OXFORDSHIRE COUNTY COUNCIL'S RESPONSE TO CONSULTATION ON THE FOLLOWING DEVELOPMENT PROPOSAL

Application no: 21/02467/F

Proposal: Erection of mixed-use development including a 240-bed hotel, 4-storey office building and roadside services including 2 no hot food restaurant drive-throughs, a coffee shop drive-through and a petrol filling station with ancillary retail store

Transport Schedule

Figure 3.2 – Indicative Public Transport Catchment

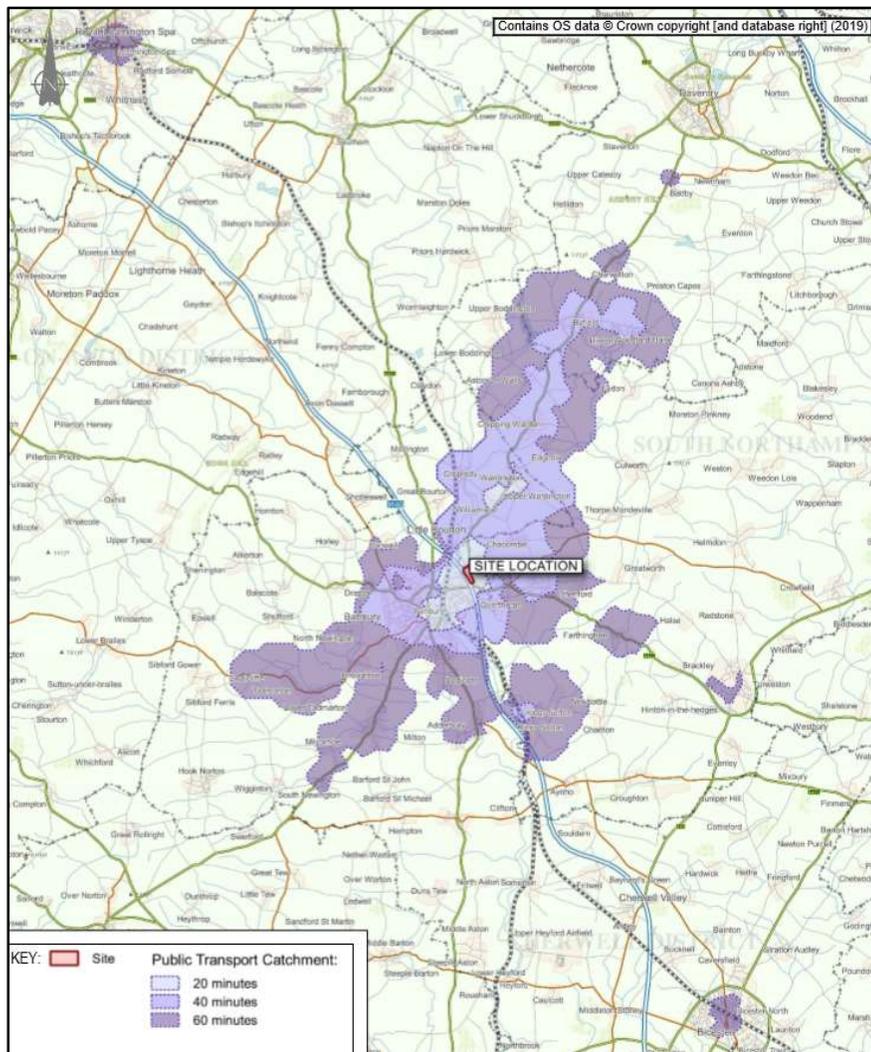
4.4.1	Diagram is misleading as it does not take into account bus frequency.
5.2.5	Projection to 2031 using Temprow – 2031 model scenario should be used, as this will be more accurate in taking account of local development.

Size:	Date:	Drawn By:	Designed By:	Checked By:
A1	26/05/21	JM	JM	JA
Scale:	1:500			
Project No:	Originator:	Volume:	Level:	Type:
76170 - CUR - 00 - XX - DR - TP -	05001	- P03

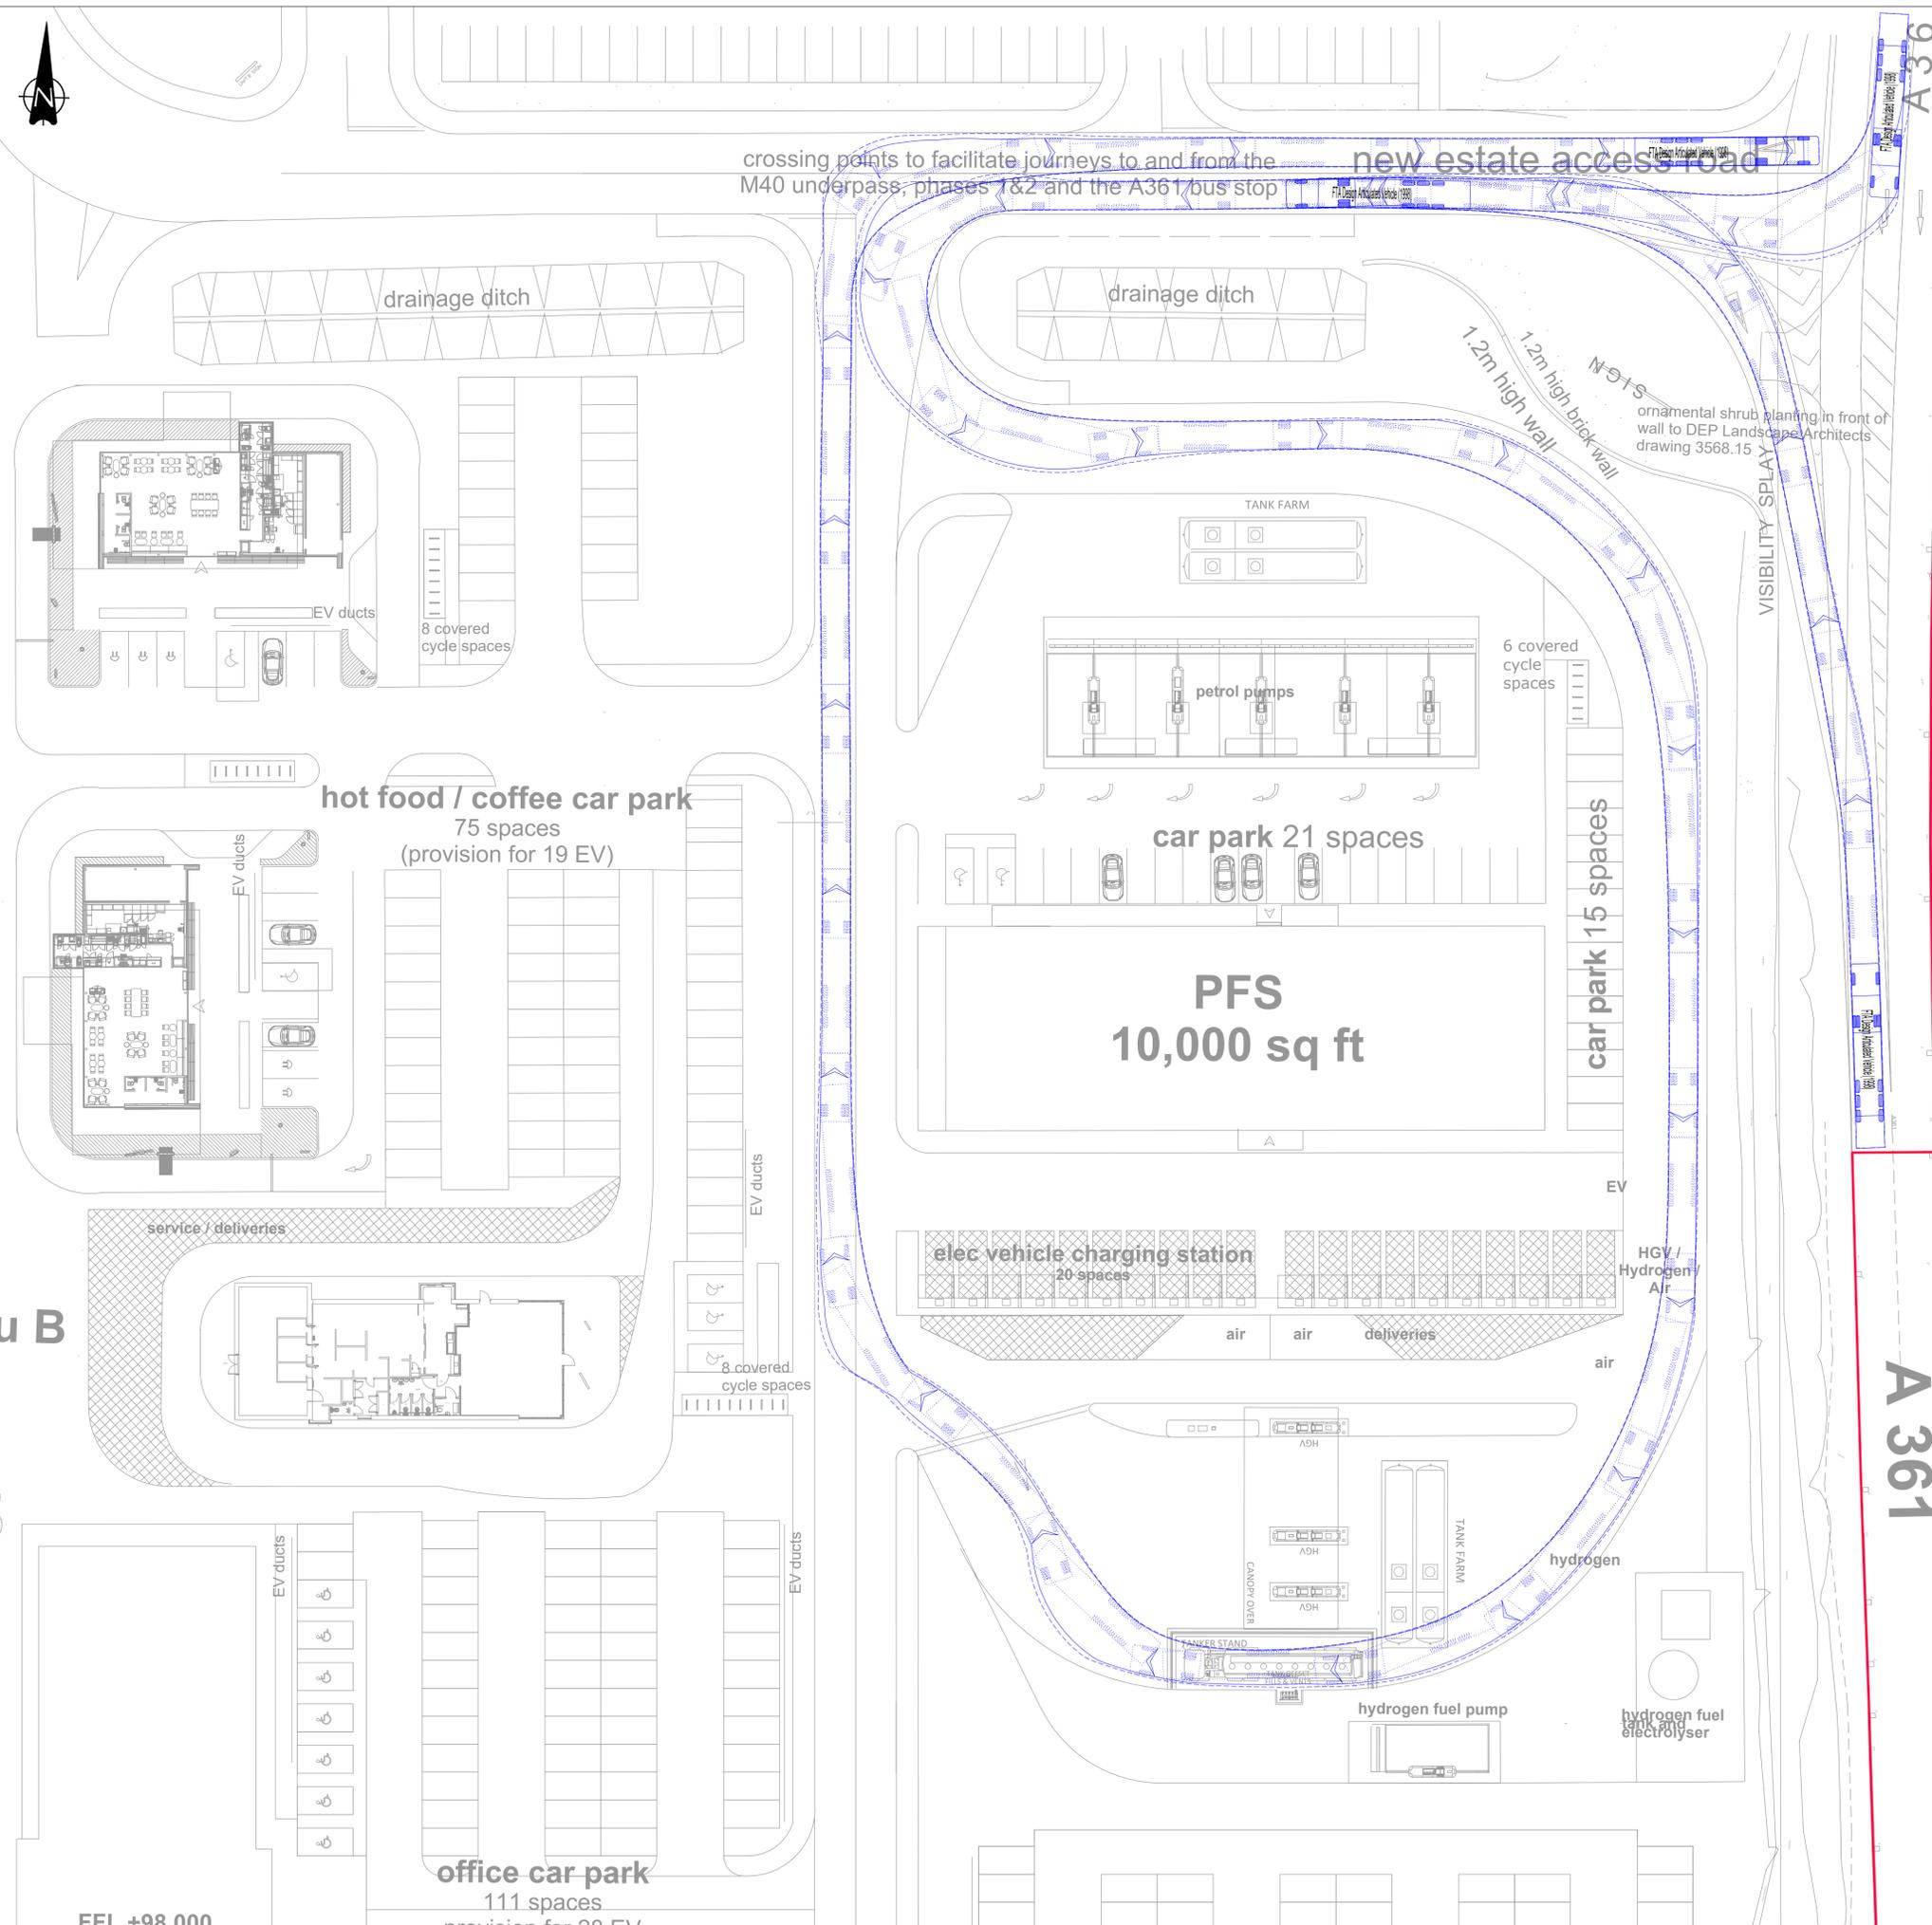
The proposed layout requires improvement to create a continuous, safe, obvious and attractive pedestrian and cycle route from this link to the development and within the development, including suitable crossings of the access road, and junctions within the site. This is necessary to promote walking and cycling as a means of access for employees, and to provide safe access for these modes.

application.
3.2.5	Internal pedestrian and cycle routes – safe and direct routes should be provided from bus stops, and routes from the ped/cycle access to the north under the M40. The routes should be indicated, showing crossing points.

3.4.5	Needs to be better ped/cycle linkage with the route under the motorway to the north.
3.4.6	No cycle parking is shown on the plans except for the hotel – the space indicated is too small. Secure, covered cycle parking is required in accordance with OCC Guidance.
